From: Julie Redpath 
Sent: 19 April 2018 11:48
To: Planning; Andrew Wood
Subject: FW: AB/25/18/A & AB/26/18/L Swan - Arundel Further Revised Drawing
Importance: High

From: Julie Redpath
Sent: 13 April 2018 16:28
To: 'planning@arun.gov.uk' <planning@arun.gov.uk>
Subject: AB/25/18/A & AB/26/18/L Swan - Arundel Revised Drawing
Importance: High

Sign C -
1 no. d/s accommodation panel fitted to the underside
of the retained existing pictorial sign and cartouche,
with new LED trough lights
Size: 900mm x 200mm
Scale: 1:10
**Decorators to paint existing wall bracket*

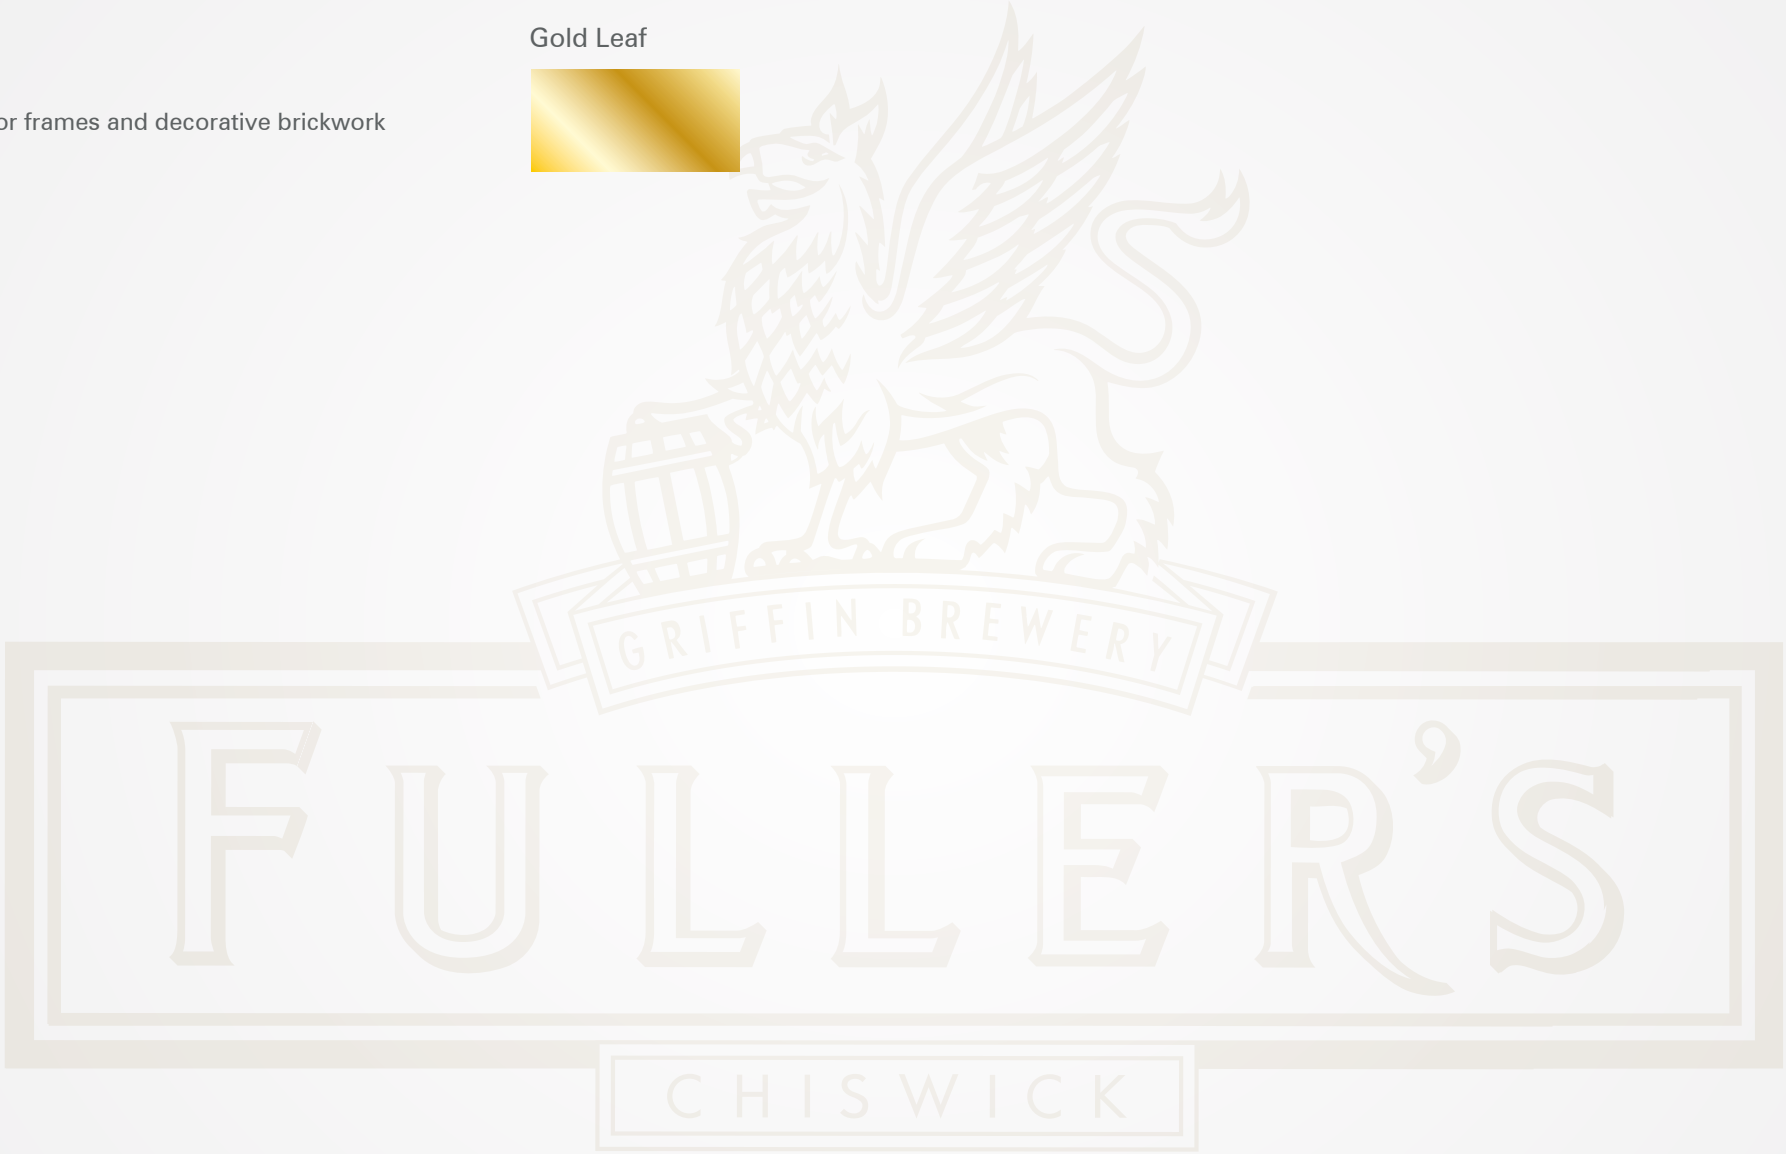
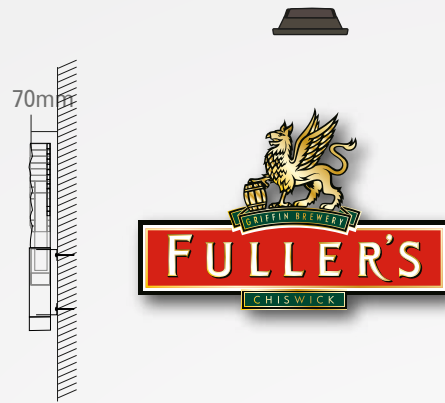
Apologies, we have been asked to amend the signage scheme further and have attached the re-revised drawing, the addition is an accommodation panel added to the bottom of the existing wall mounted pictorial sign the size is 900mm long x 200mm high and 50mm deep with approx. 50mm gap between the panels, the construction is the same as the existing pictorial and the height from the ground to the underside is 3770mm.
